Management and Maintenance Plan
Including Additional Info for the LLFA
For the surface water drainage system

For Phase II and III

Mitton Road Business Park

REF:- 102 **REV A – 13th October 2025**

**Surface Water Impermeable Area Plan
Design Criteria, Time Area, Network Details
Network Results & Pipeline Schedule.
Outfall Details, Hydrobrake Specifications, Tank Details**

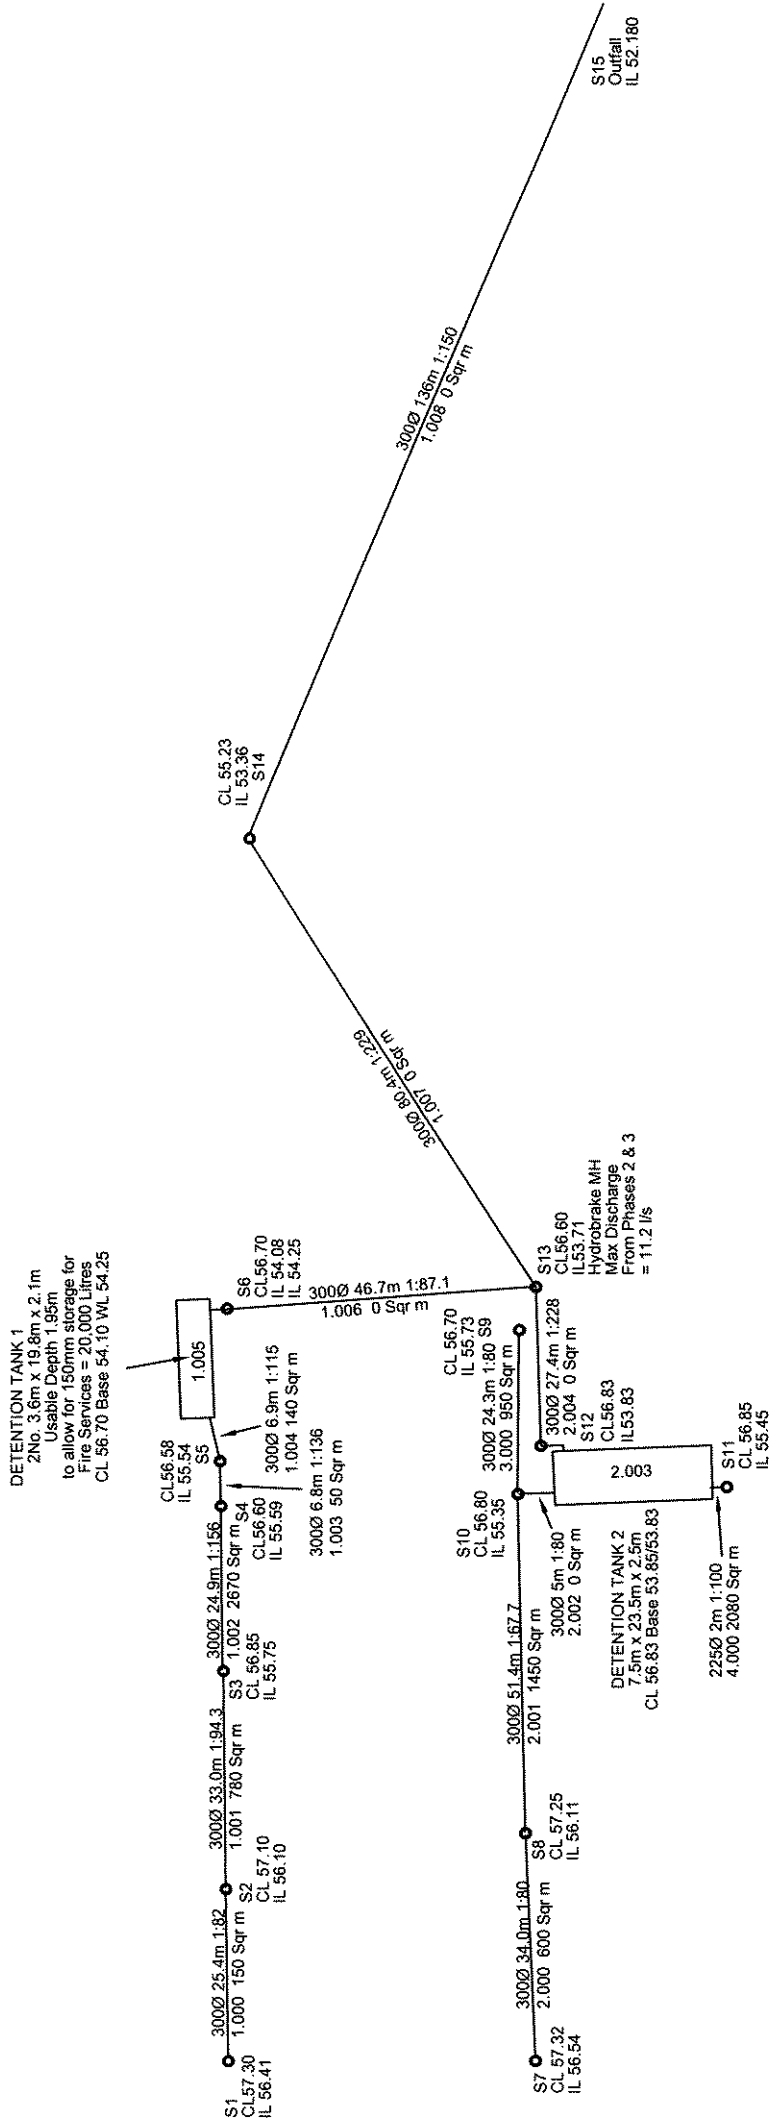
Further to the LLFA's comments dated 12 August 2025, ref application no 3/2025/0561; the following information has been provided and is included within the application.

- Catchment Plan; please refer to D and D Drainage Drawing D102 "Surface Water Impermeable Area Plan."
- D and D Drainage Drawing D013 "Flood Exceedance Plan"; indicating floor levels, adjacent ground levels and flood water exceedance routes.
- Additional information in relation to timetable for implementation, funding arrangements for on-going, regular and irregular maintenance and means of access for maintenance. All of which is set out in the maintenance section below.
- Evidence of site investigation and infiltration results below:-
